Application by Uniper UK for an order granting development consent for the Connah's Quay Low Carbon Power Project (EN010166)
The Examining Authority's written questions and requests for information (ExQ1): Issued on 17 February 2026
Responses are due by deadline 3: 10 March 2026

| CQLCP | Connah's Quay Low Carbon Power |

FIGURE TITLE
Abnormal Load Routing Options
Sheet 8 of 10

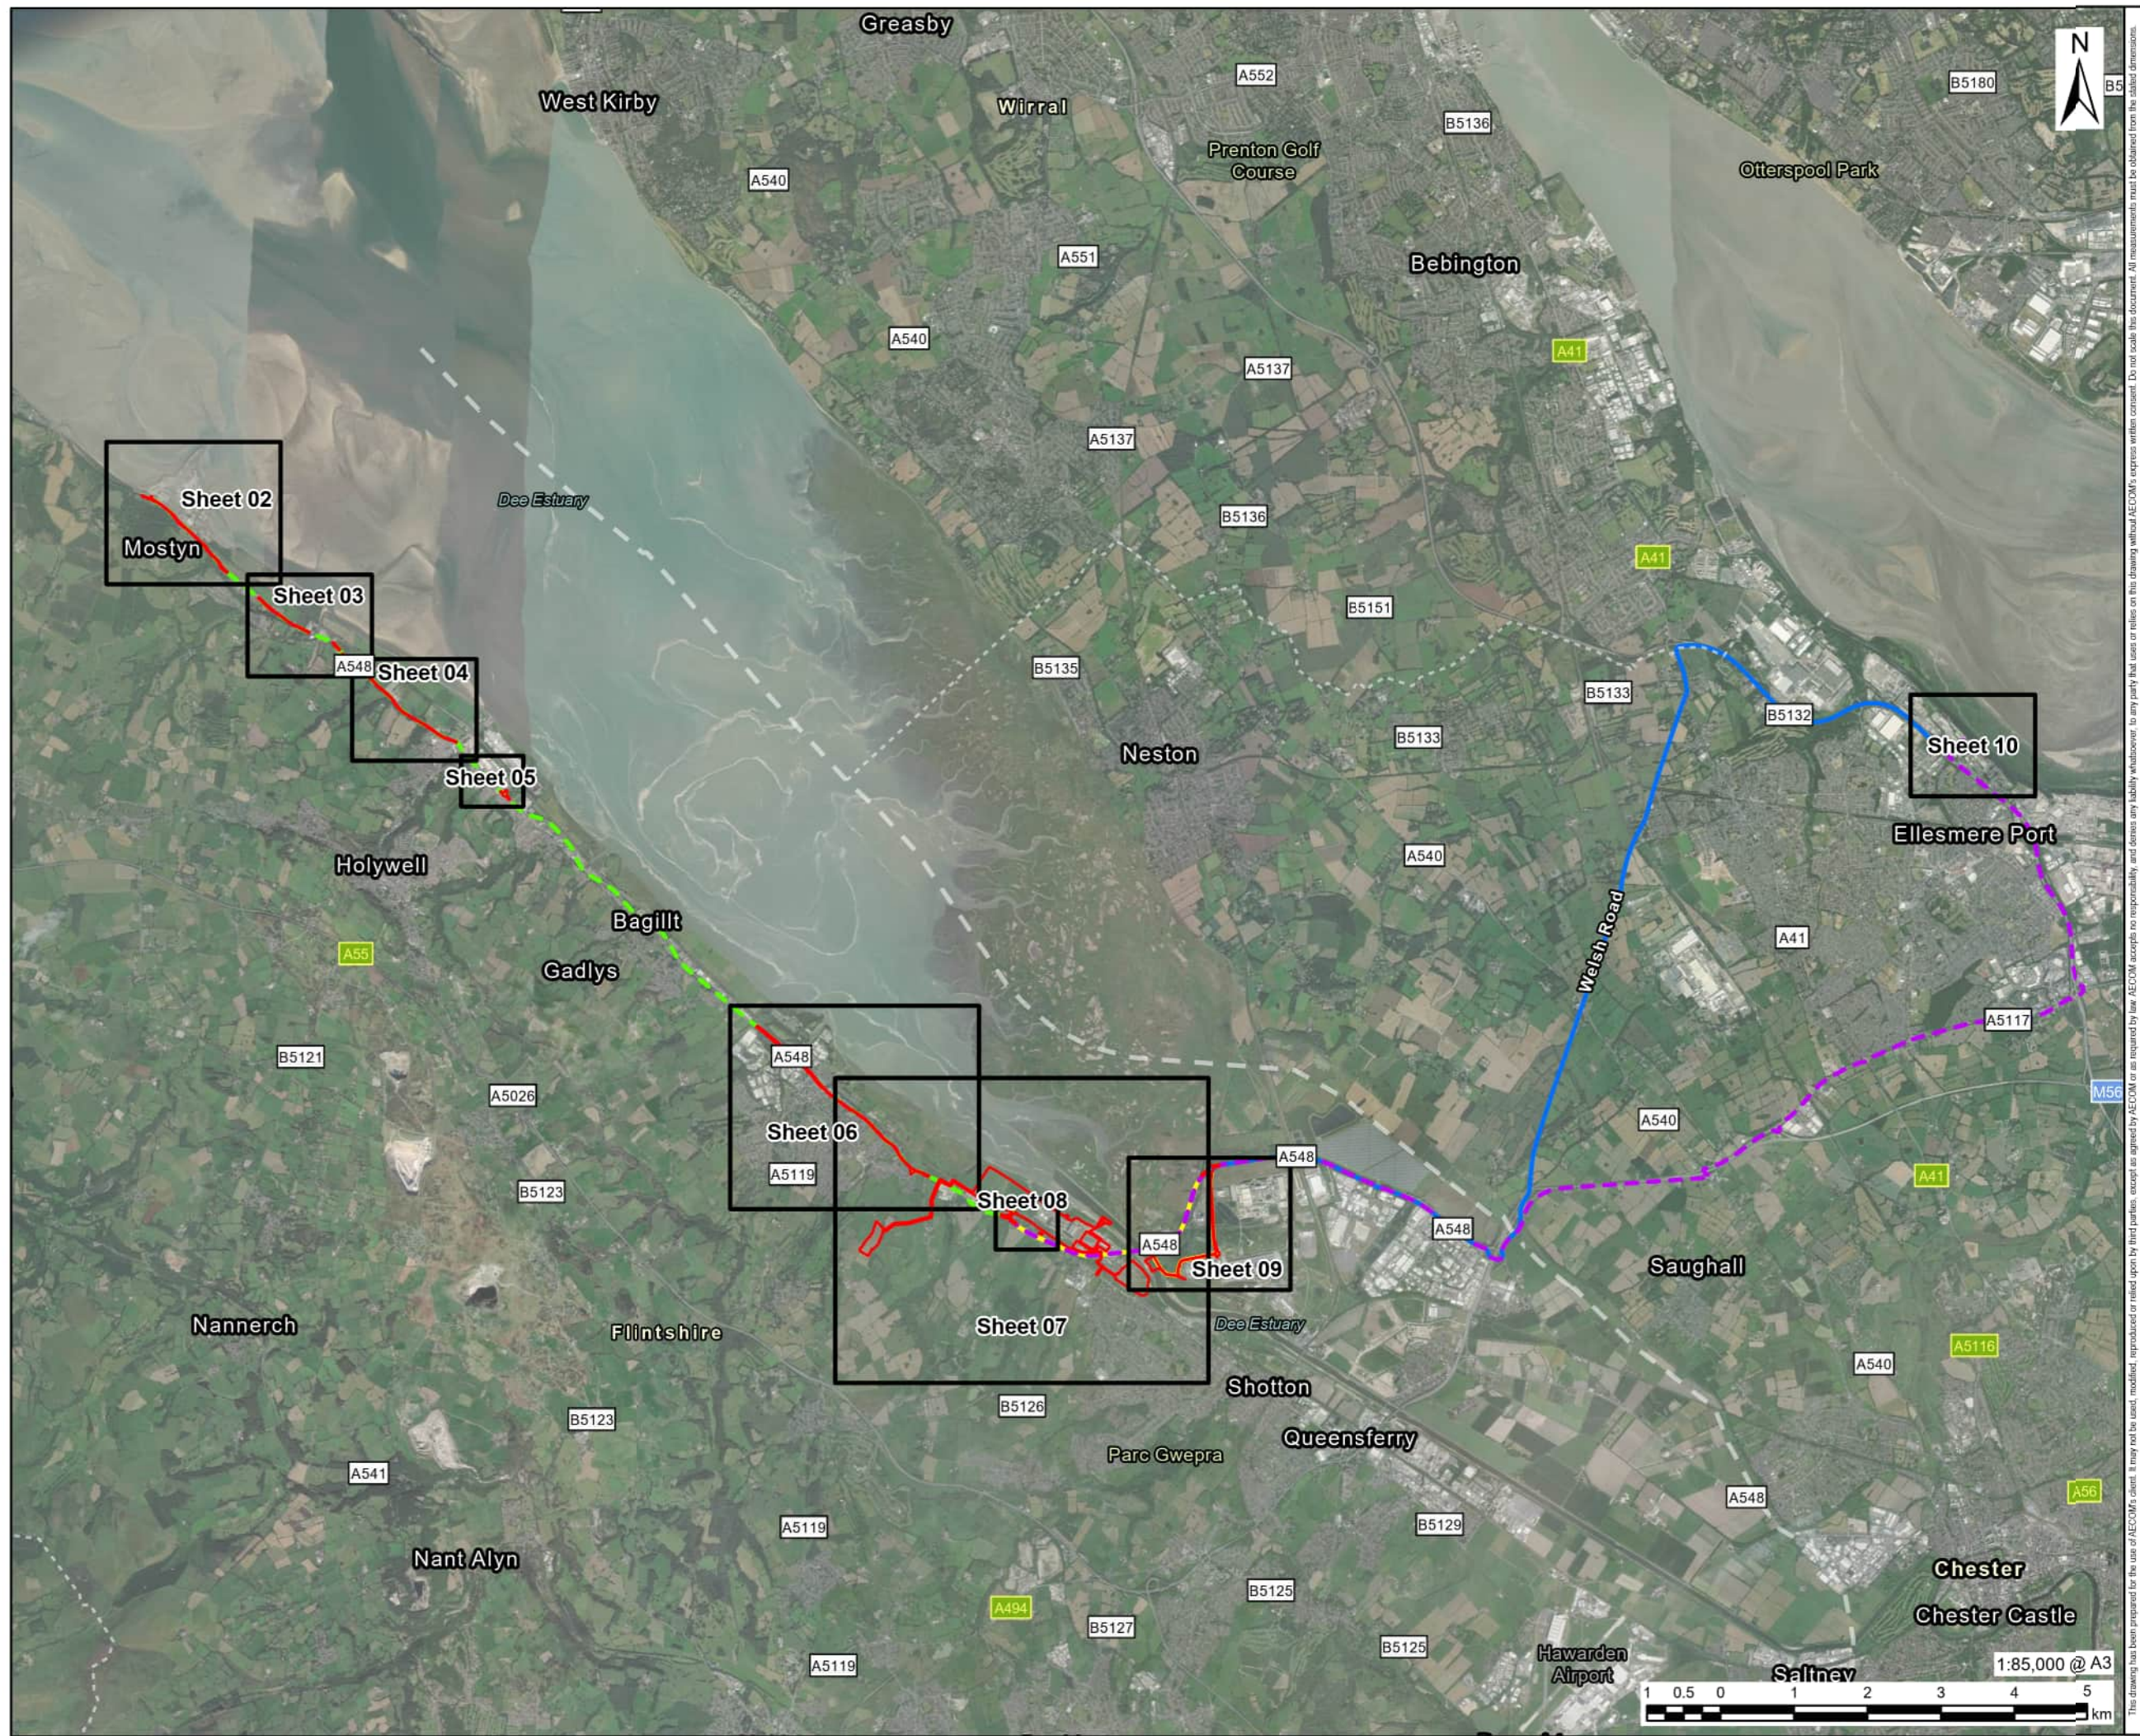
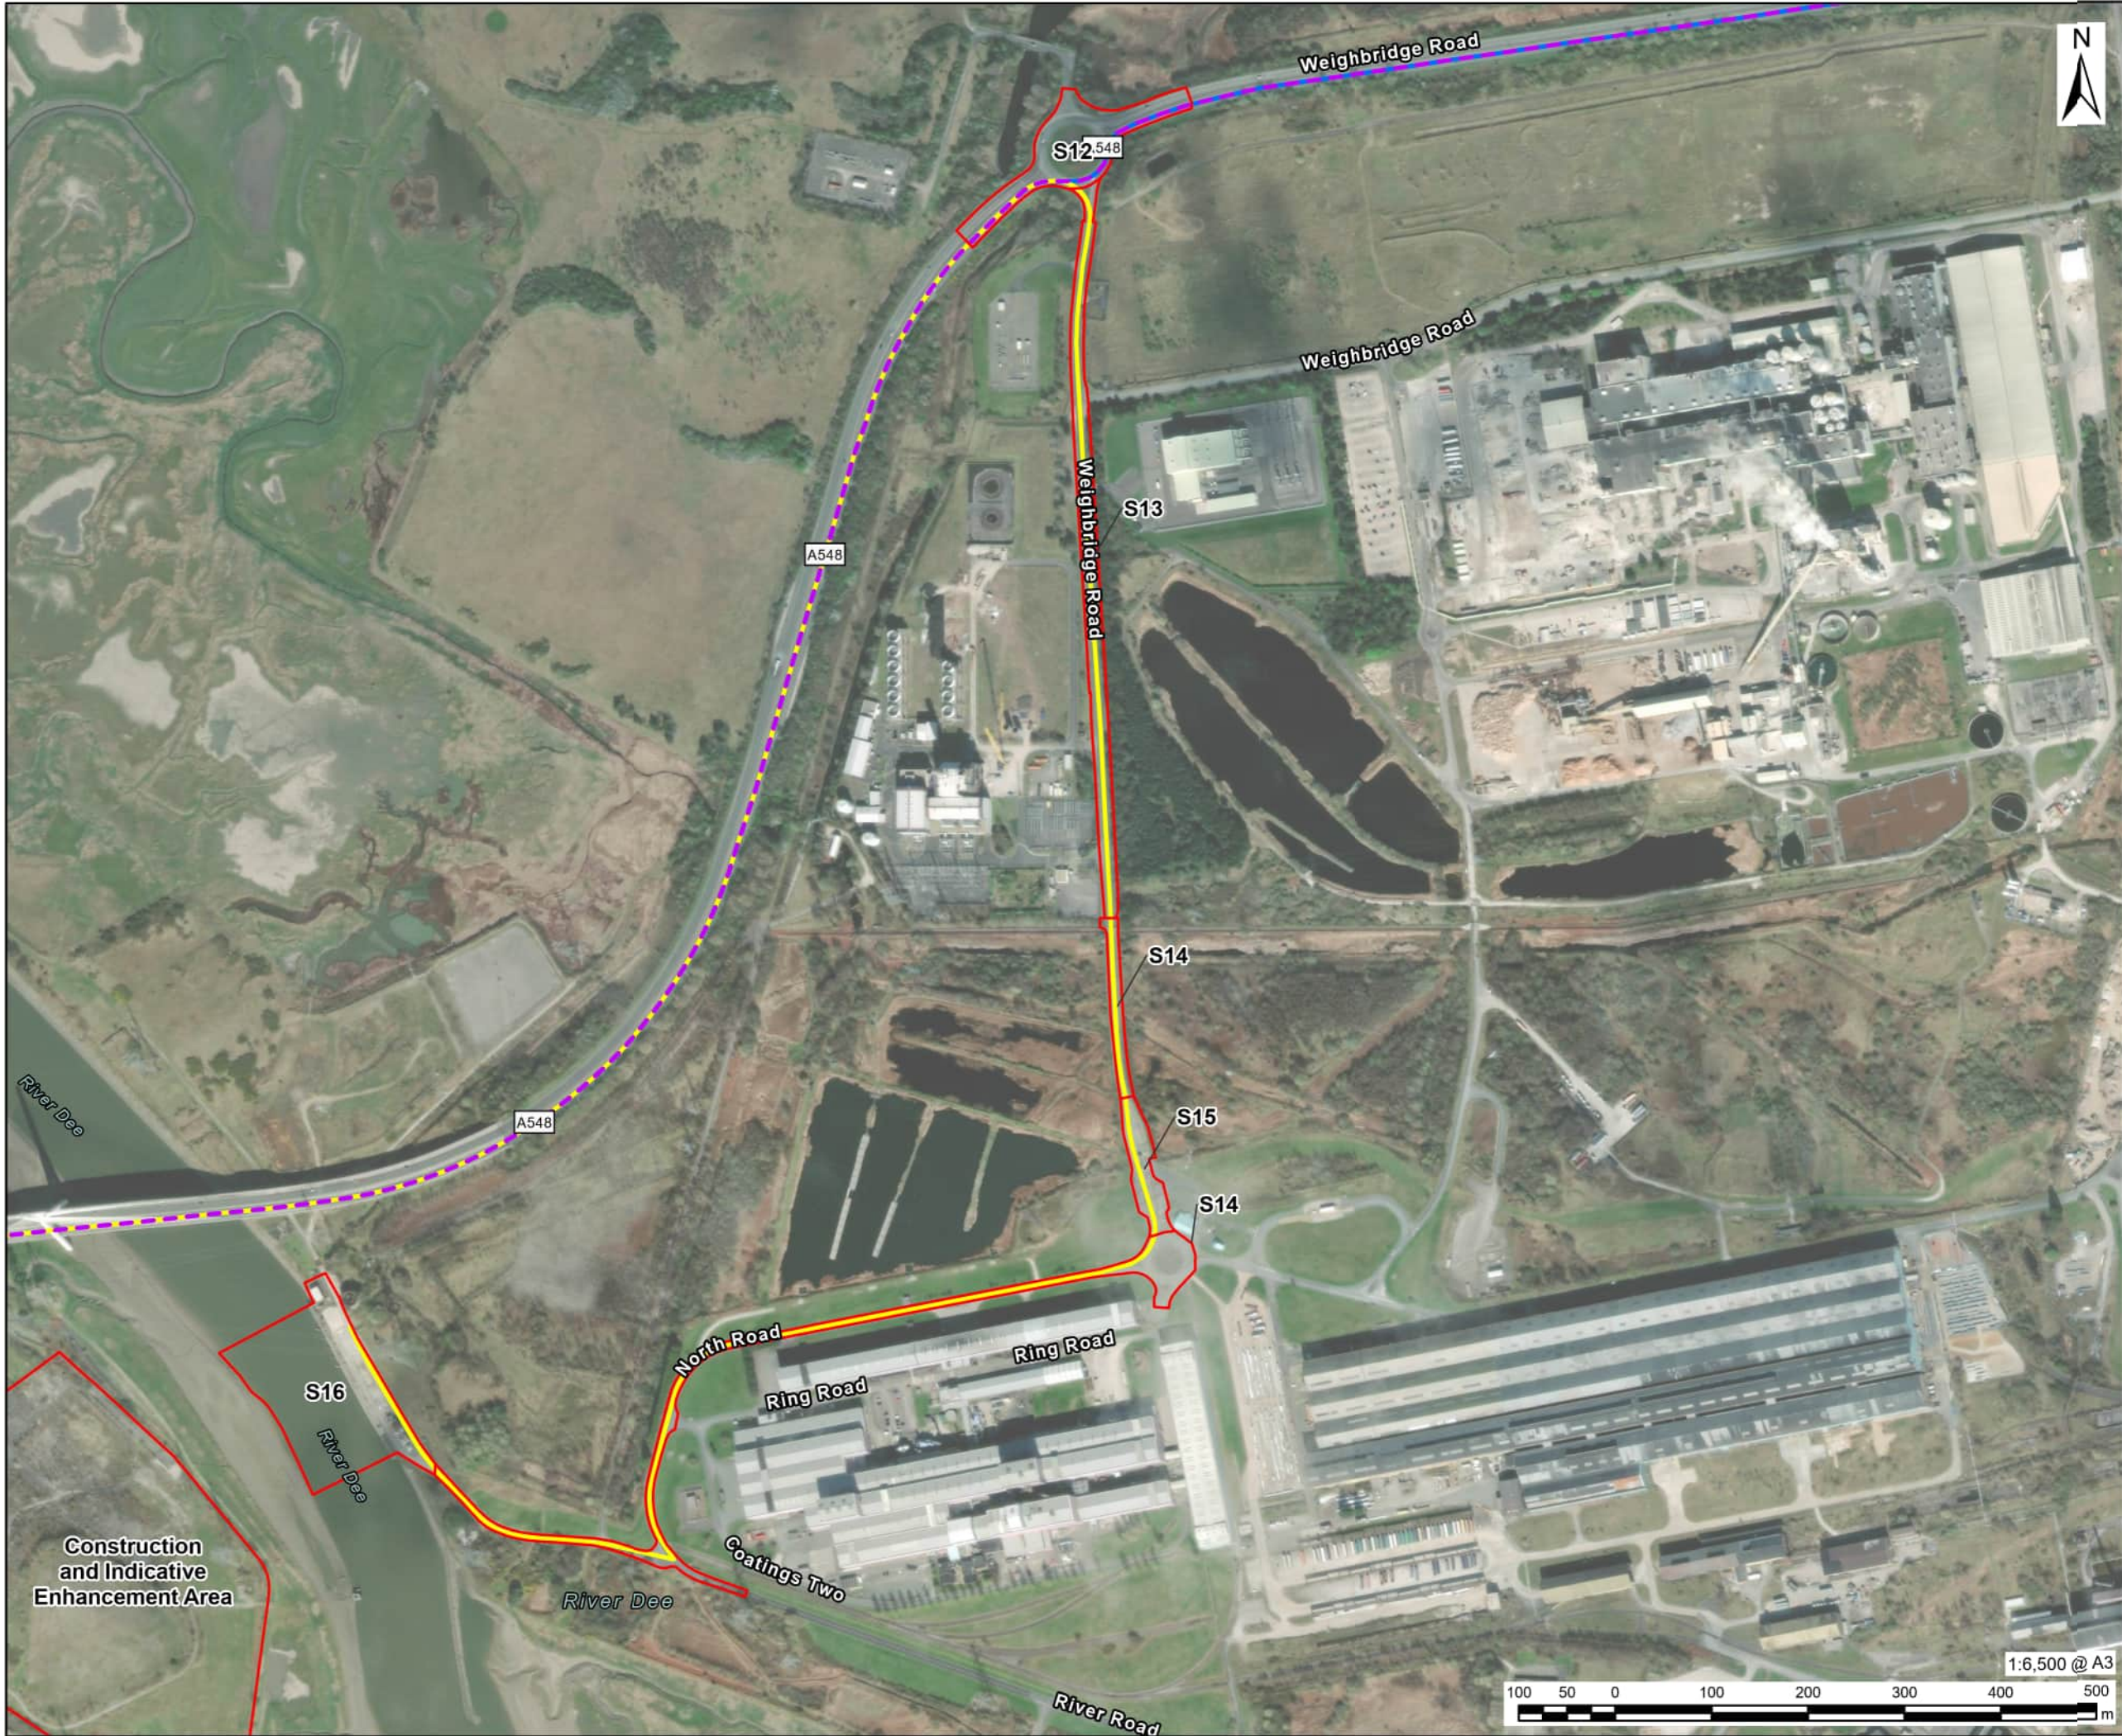
| ExQ1 | Question to: | Question: |
|--------------------------------|--|---|
| Q8.1 | The applicant | Optioneering of abnormal indivisible loads (AIL) routes Presently the application highlights three potential routes for the movement of abnormal indivisible loads (AIL). At what stage will an option be decided upon, and if is this likely to occur during the examination ? If so, will the order limits and extent of assessment for the proposed development be reduced accordingly; or If not, can the applicant provide reasonable justification for the consideration of disruption and consideration owing to the extent and length of highway being considered? In addition, can the applicant provide further justification as to the need for the use of powers within the order limits rather than relying on the more usual use of legislation and permitting for the movements of AILs? |
